**HIGHWAY REPORT ON PROPOSALS FOR DEVELOPMENT**

<b>DISTRICT:</b>	Bassetlaw	Date received	09/08/2022
<b>OFFICER:</b>	David Askwith		
<b>PROPOSAL:</b>	Change of Use of Agricultural Buildings into Two Dwellings with Associated Building Operations (Re-submission of P.A 21/01255/FUL)	D.C. No.	B/22/01045/FUL
<b>LOCATION:</b>	Forwood Farm Wood Lane Treswell Retford Nottinghamshire DN22 0EE		
<b>APPLICANT:</b>	Mr M Bell

Drawing Number: **2021/24-A2-P100** Rev: **P2**

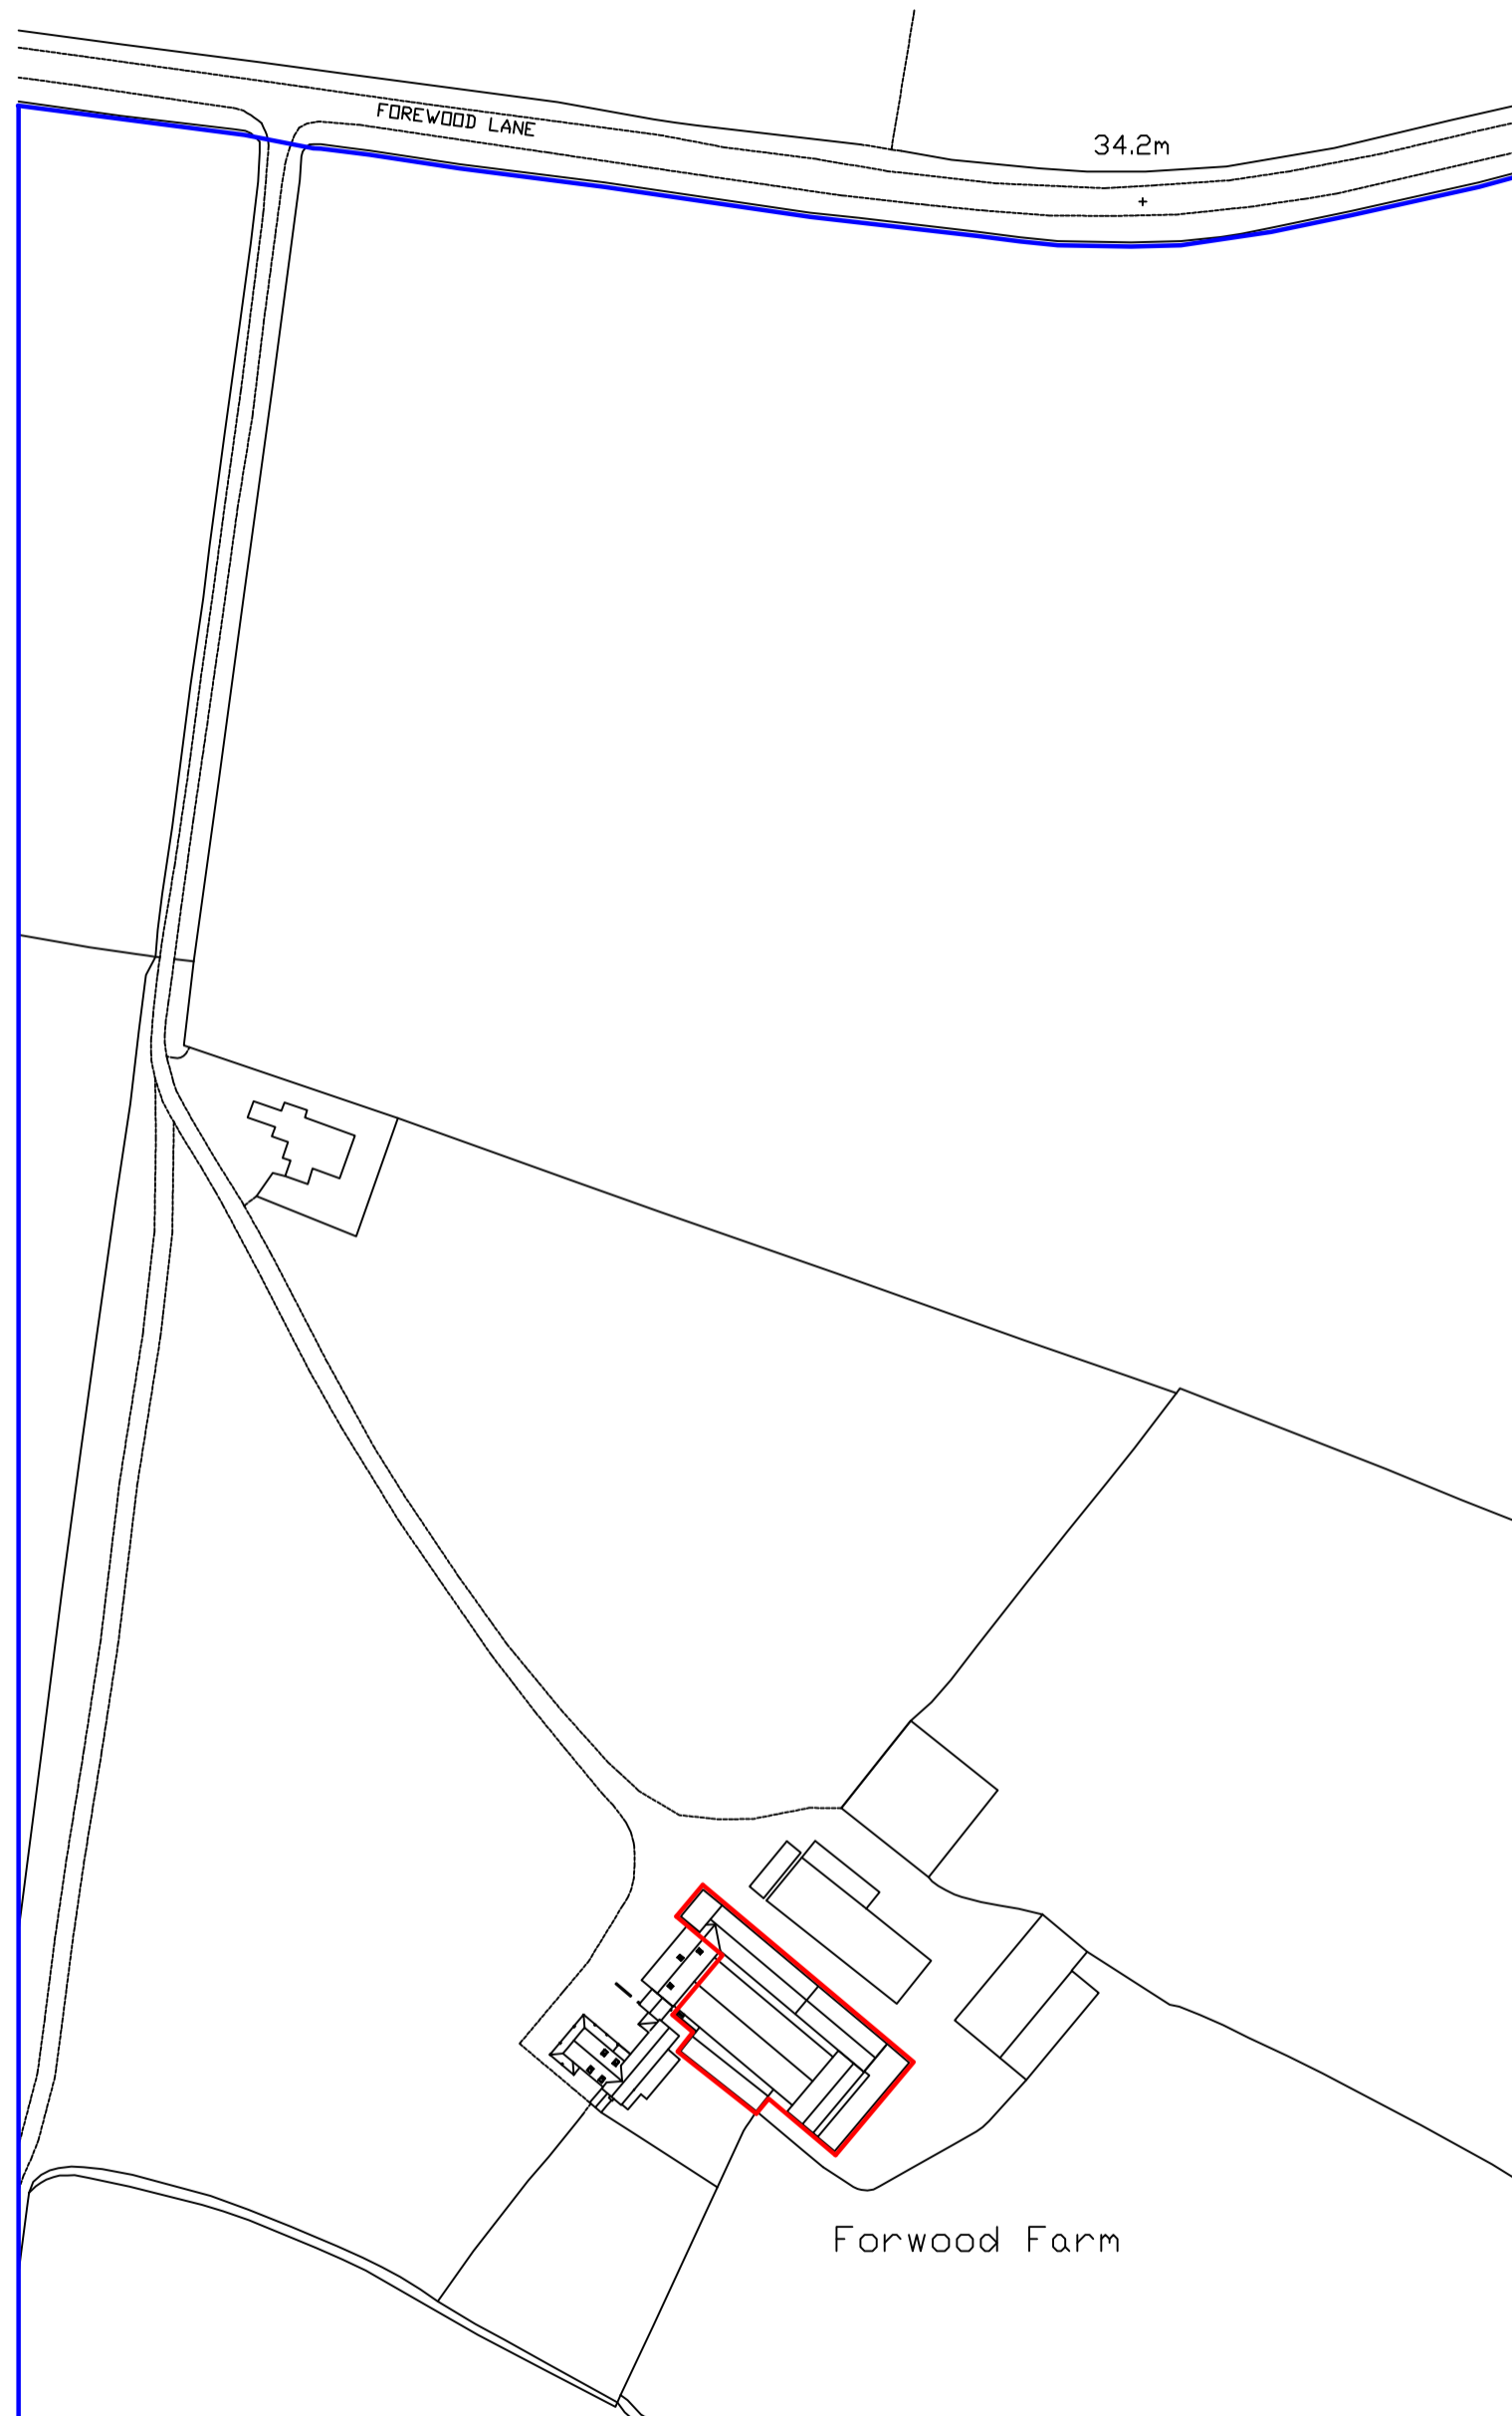
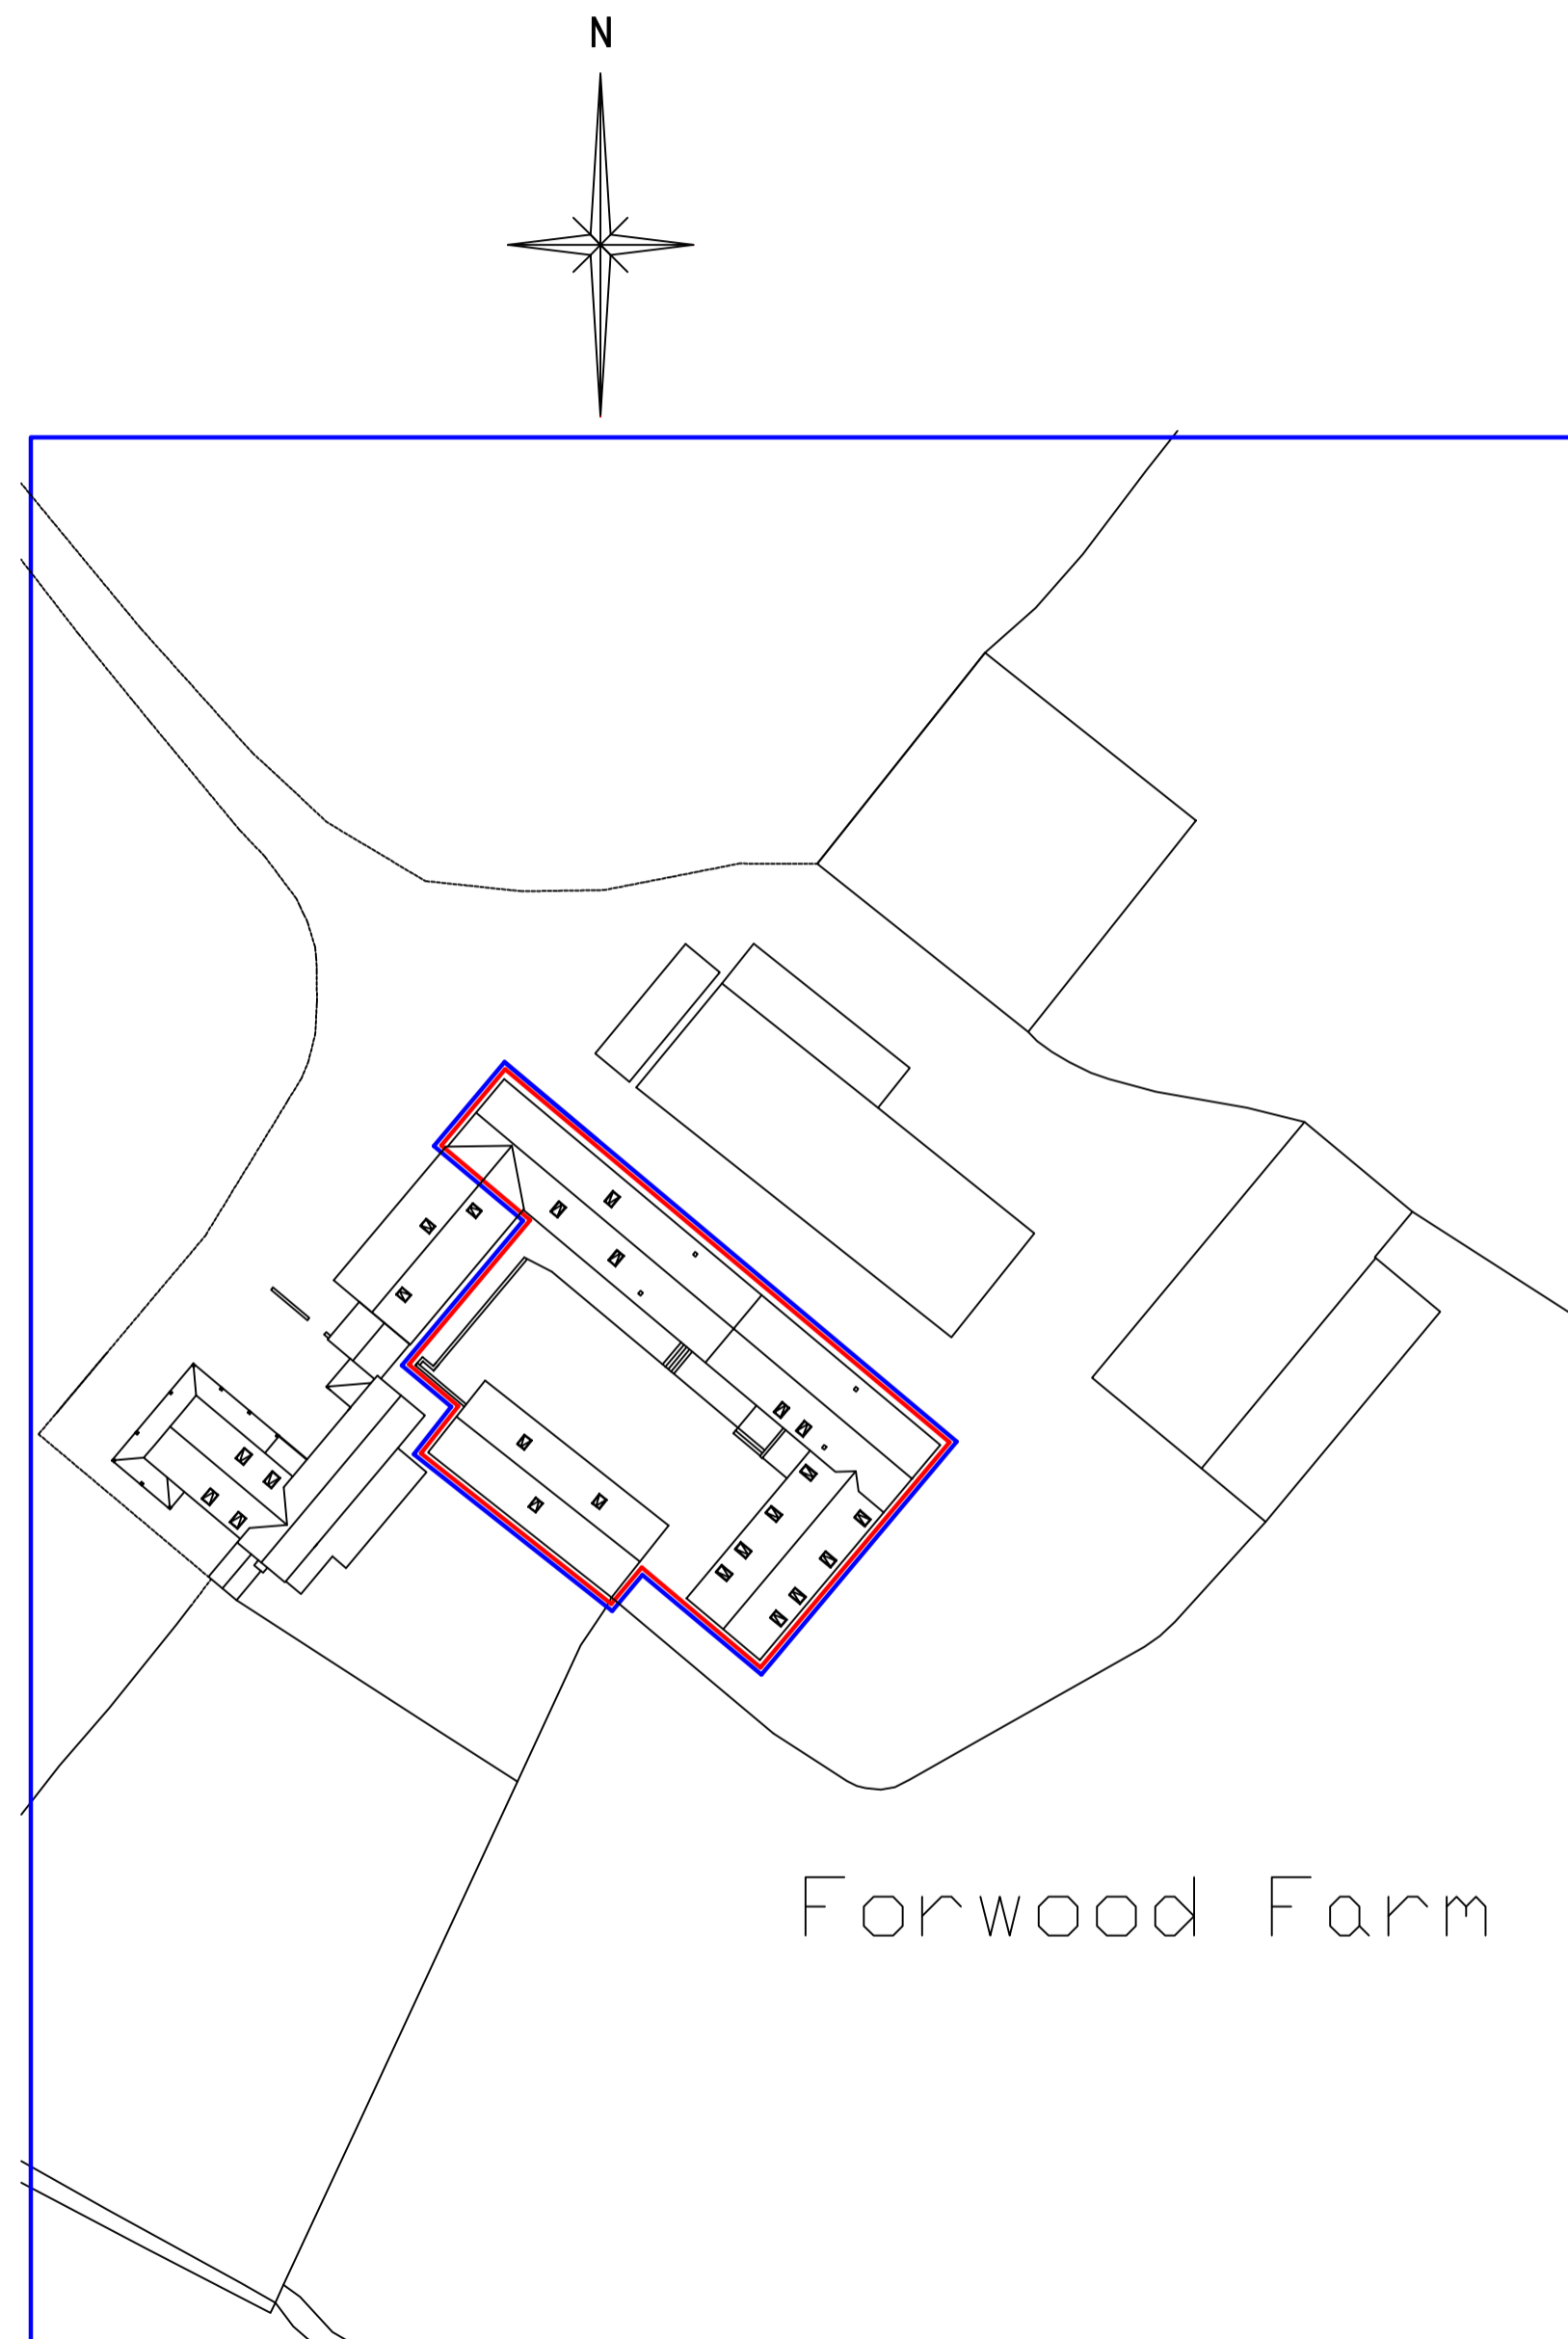
The site is served from Wood Lane via Treswell Bridleway 14. This would benefit from widening at the junction to allow two vehicles to pass. However, the proposal is unlikely to represent an intensification of traffic considering the building's potential use. It is recommended that the Rights of Way Officer be consulted with respect accessing the development from a bridleway.
